COMMUNITY DEVELOPMENT DEPARTMENT
501 Delta Avenue ♦ Marysville, WA 98270 ♦ (360) 363-8000

Re: PA23-005 – Creekside PRD – Technical Review 3
7808 40th Street, 7811 & 7715 40th Street NE, APNs 29050200100200,
29050200100300, and 29050200100400

MEMORANDUM

MEMORANDUM

**LINE ROAD/ 44TH STREET NE TYPICAL ROAD SECTION**

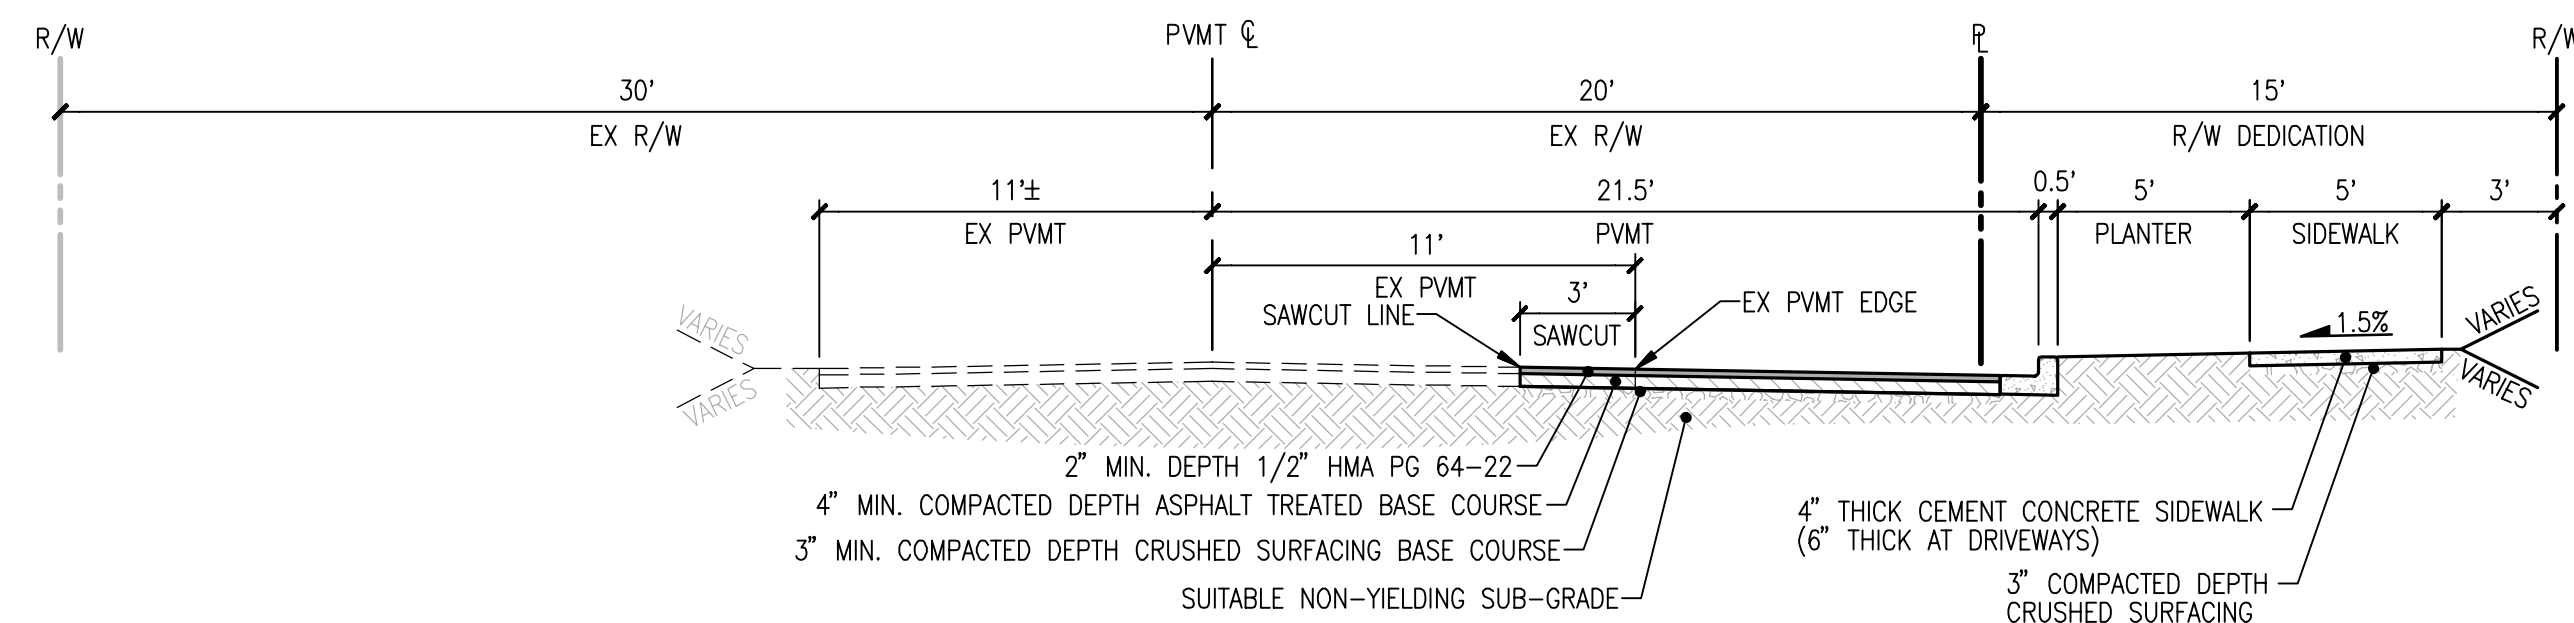
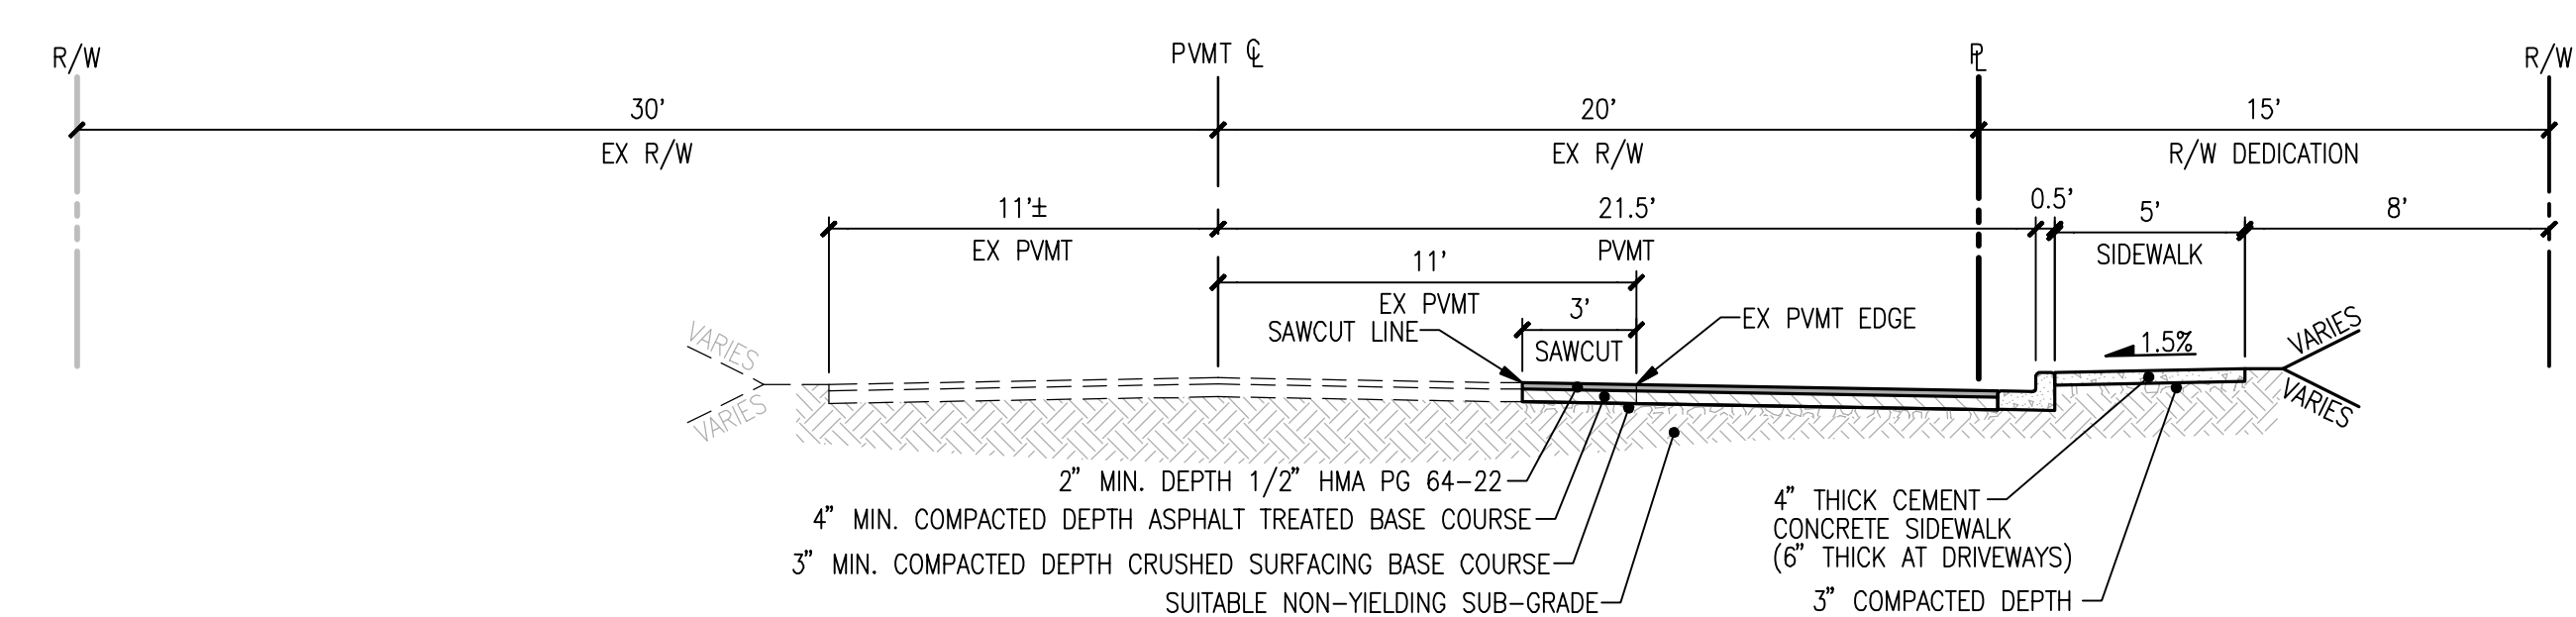
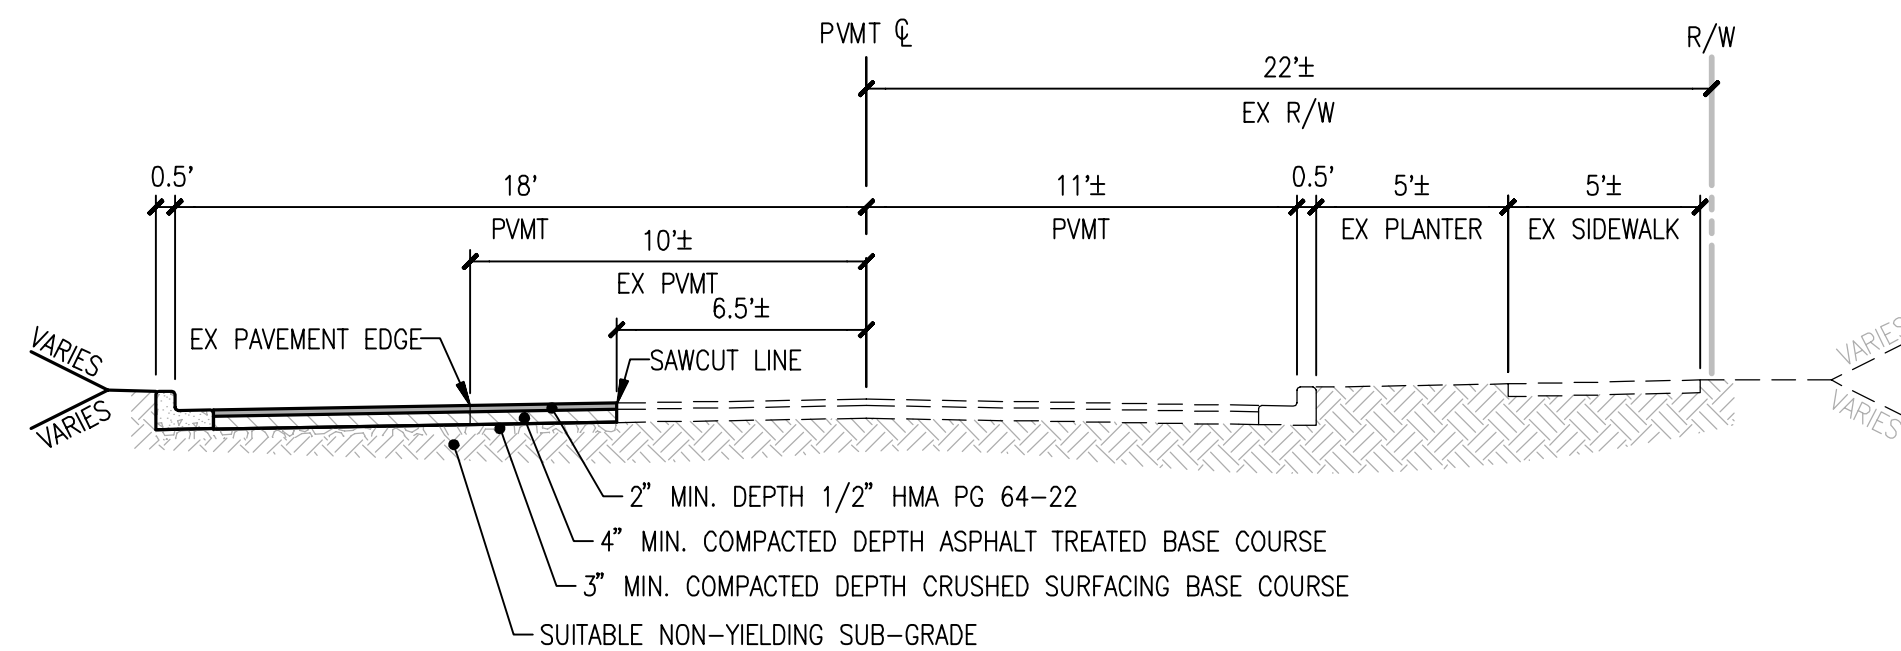
- 3) Undergrounding of existing overhead utilities along all public roadway frontages shall be required.
- 4) Frontage improvements shall be required upon 44th ST NE.

- a. 44th ST NE is designated as a Collector Arterial.
 - b. Roadway cross-section shall be 70' ROW three lane roadway with bike lanes per EDDS Standard Plan 3-201-004.
